THANET FISHERMEN'S ASSOCIATION.

Thanet Extension Offshore Windfarm. Planning Inspectorate-Application by Vattenfall Wind Power Ltd for an Order Granting Development Consent.

ISH 8 Hearing Action Points. Thanet Fishermen's Association representation regarding impact level scoring.

Datum: ETRS 1989  
Projection: UTM31N

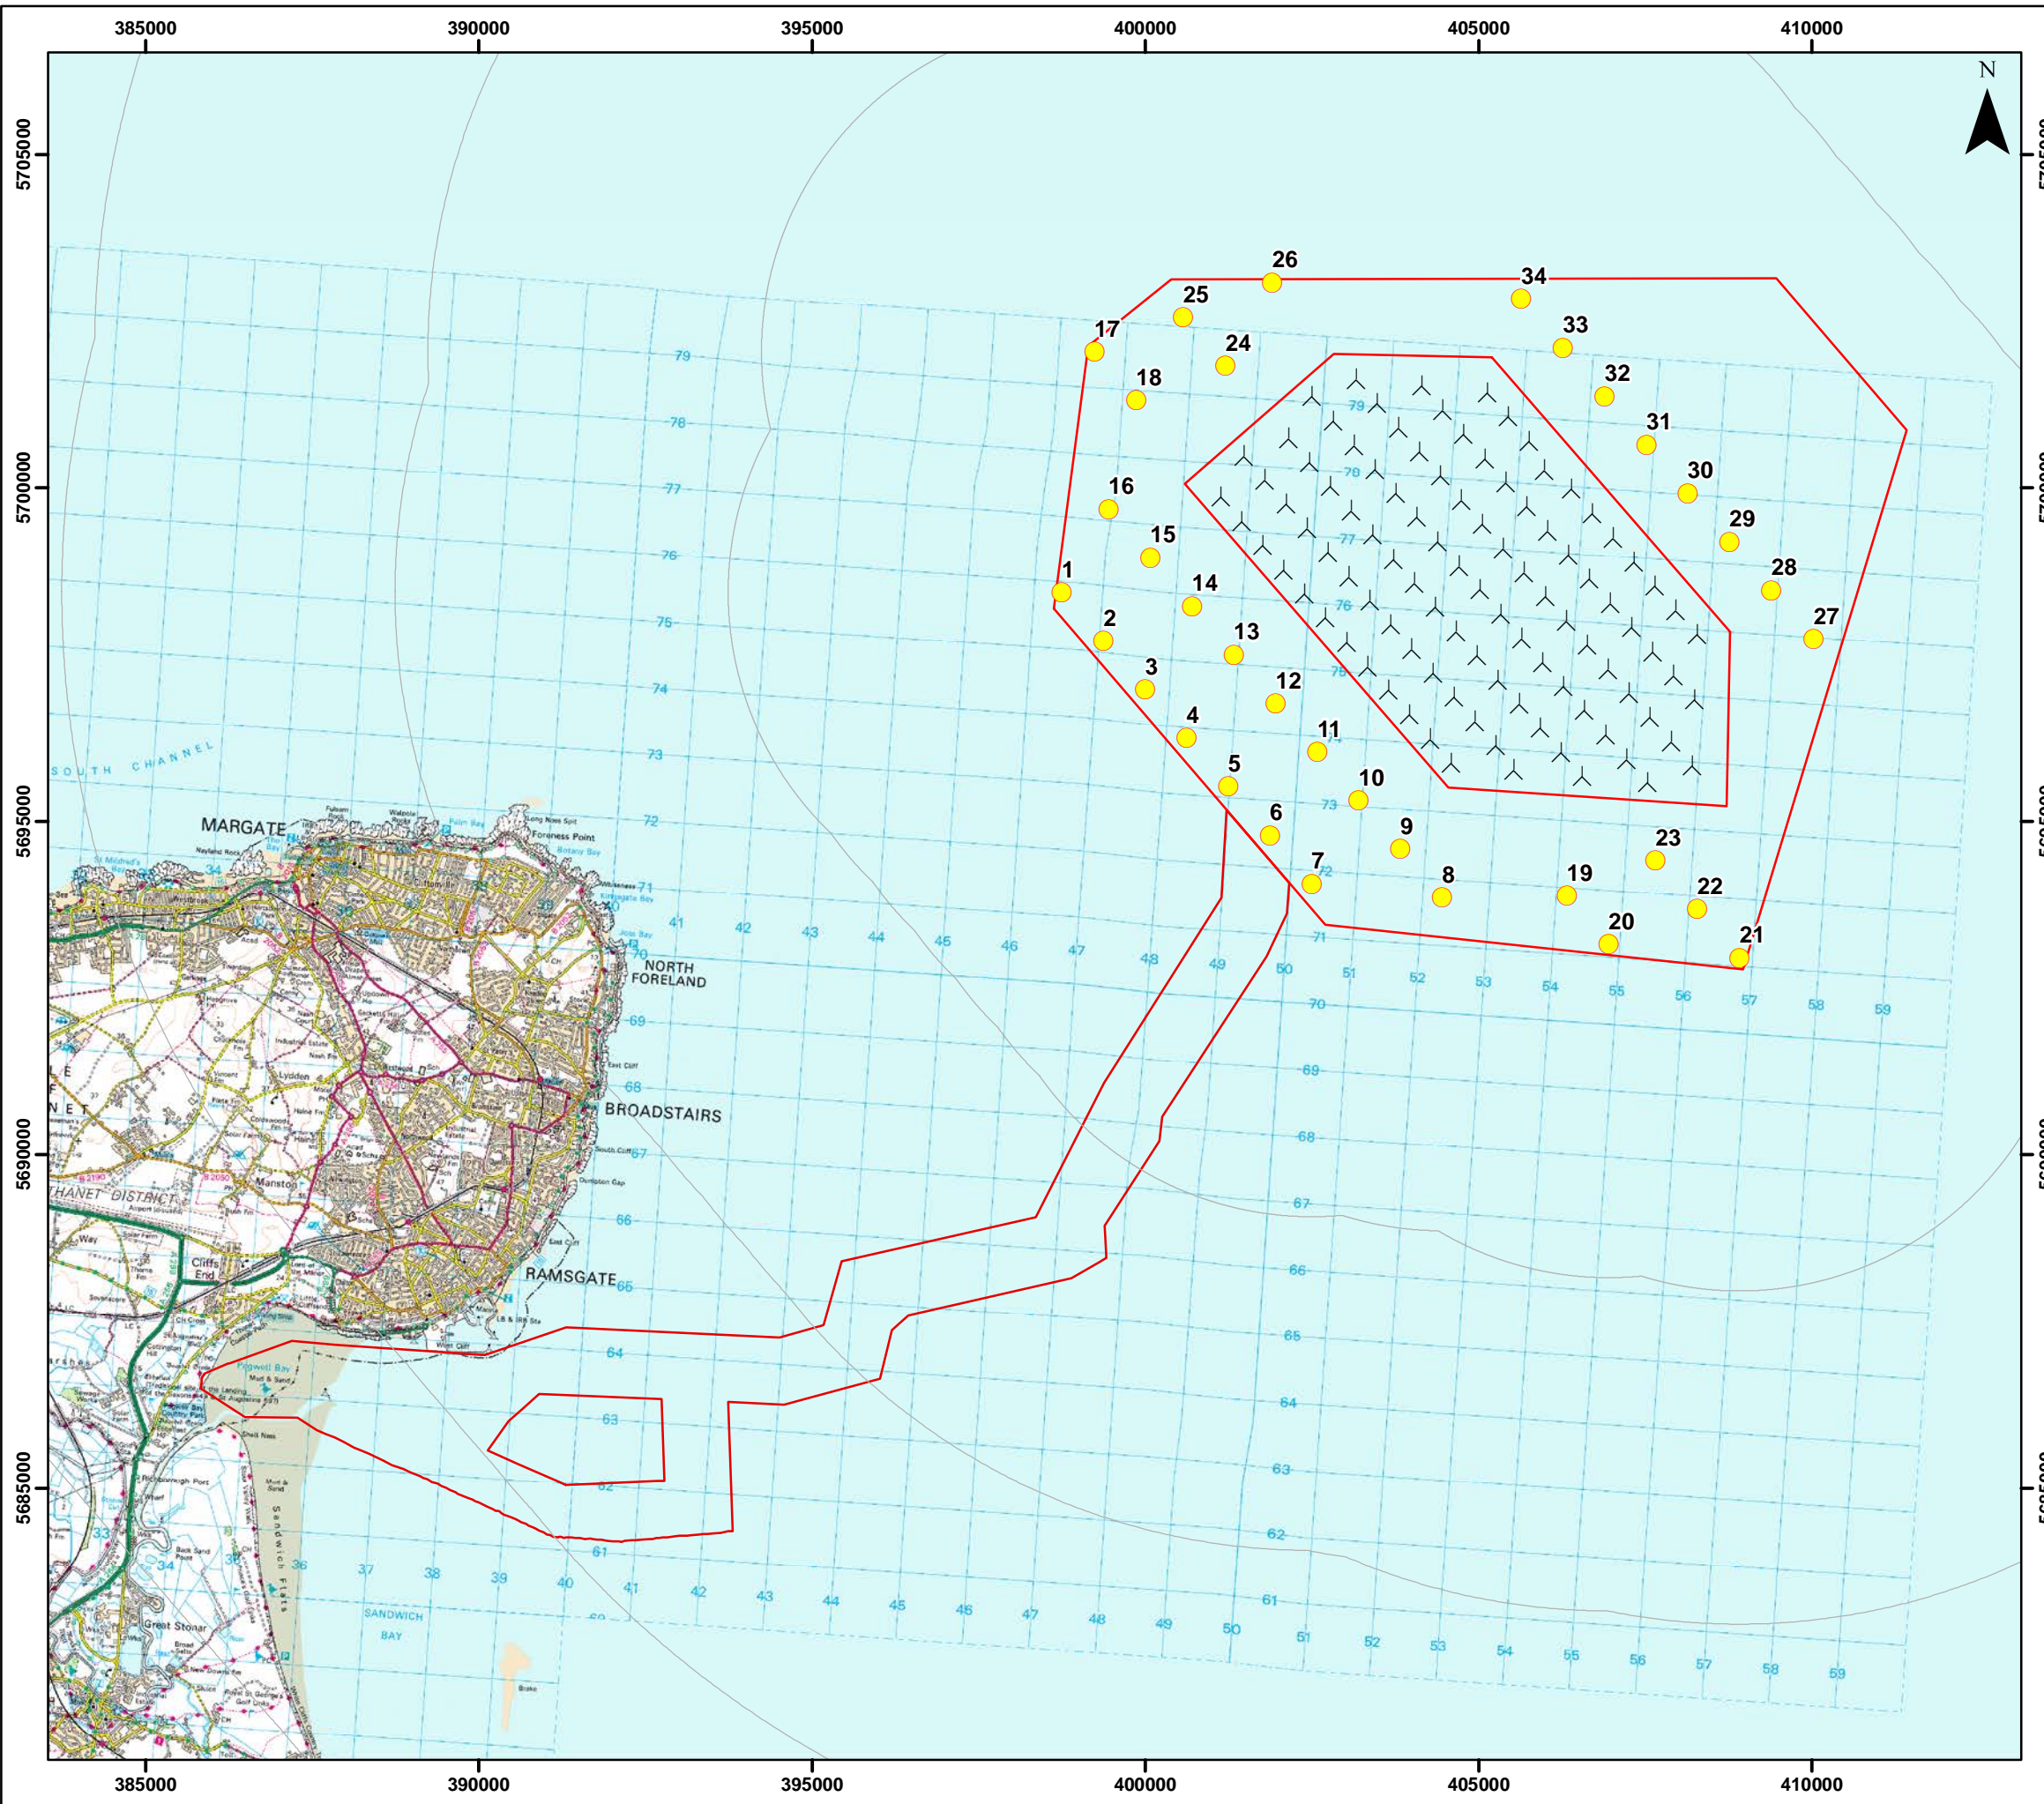
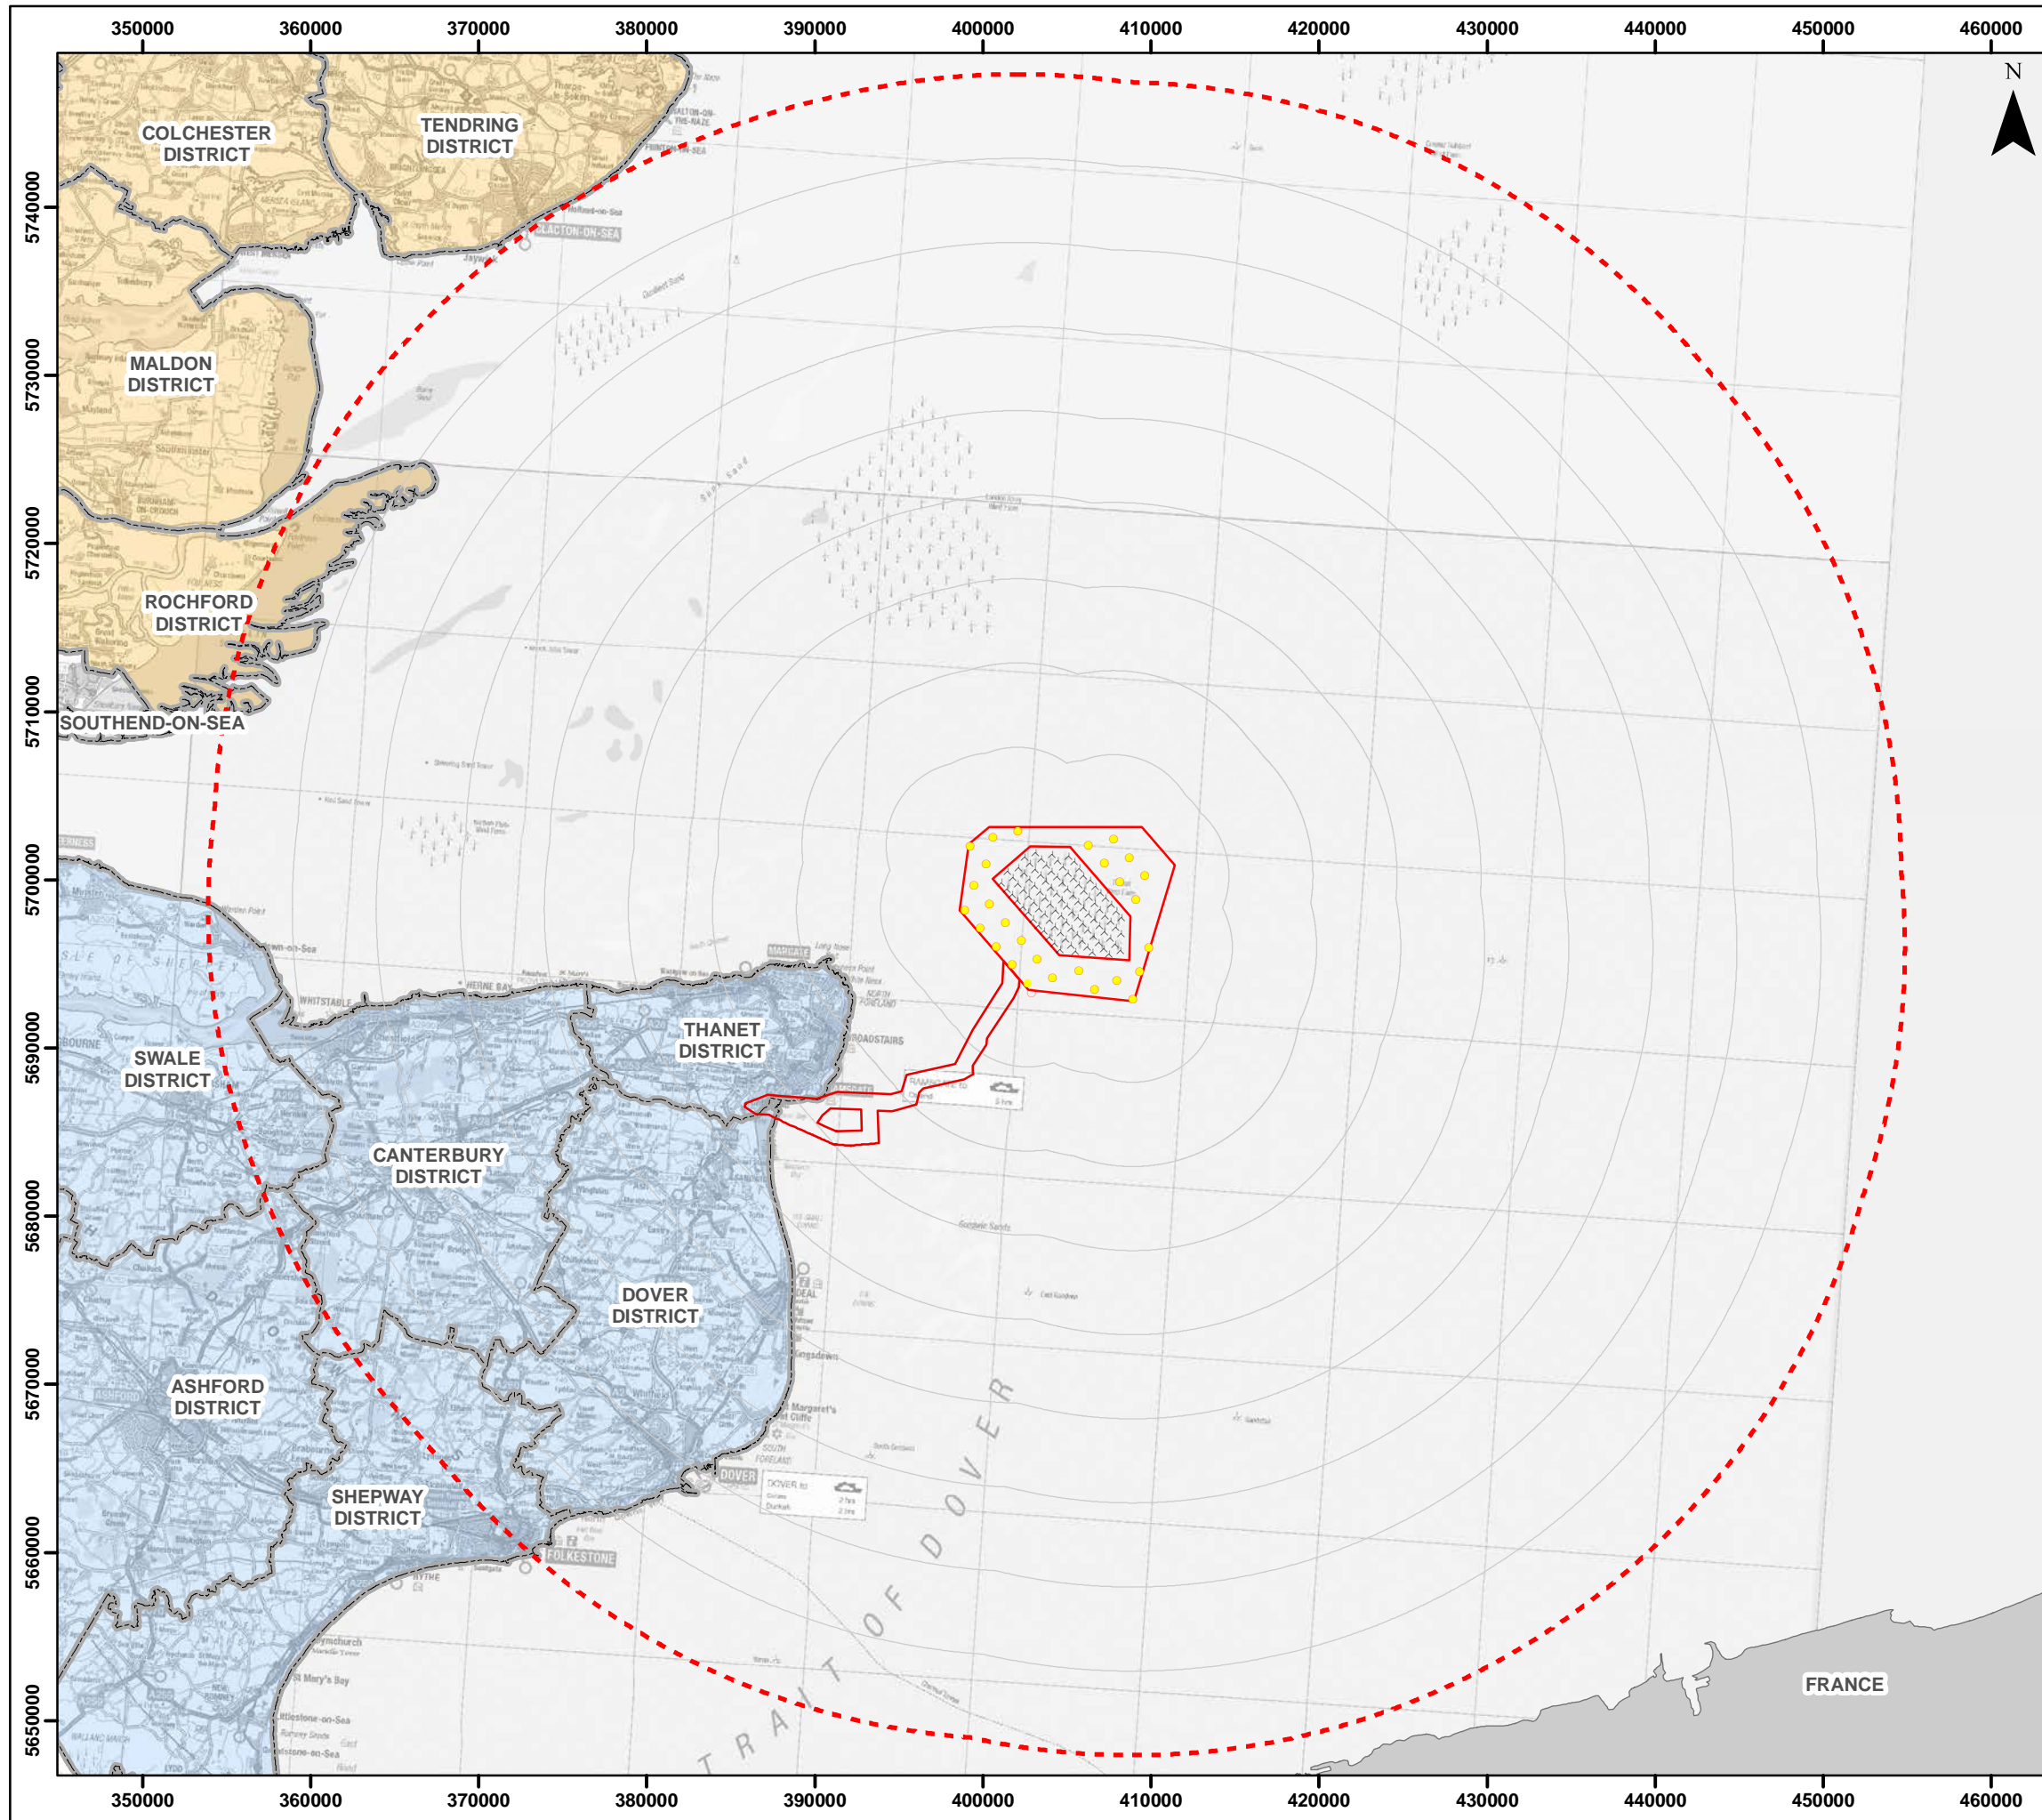
The latest indicative layout, Annex A to Appendix 3 of deadline 4b submission figure 12.1a SEZ, shows that both potting areas within the RLB will have monopiles placed within them. This means that when the potters return after construction, they will not be able to return the same numbers of pots to the ground due to the footprint of a monopile and safety zone, an approximate loss of 9000 square meters per monopile (based upon a 50m safety zone). Until a definitive monopile position is clear, it is hard to estimate how many pots will be displaced but these will either be added to the pots along the shoreline, and to the smaller areas, or will no longer be worked at all.

Figure 9 above shows the Drift ground used by Fishing vessel Defiant during June 2017, as discussed at ISH 6. The Defiant consistently fishes these drifts and her [REDACTED] tracks for the year 2017 show her in and around the same area. Approximately 90% of her annual earnings come from this area. The indicative layout prior to the SEZ showed monopiles in the Northern, North Eastern and South Eastern drifts. Since the introduction of the SEZ, the revised indicative monopile layout now shows an increased number of monopiles in all three drift areas.
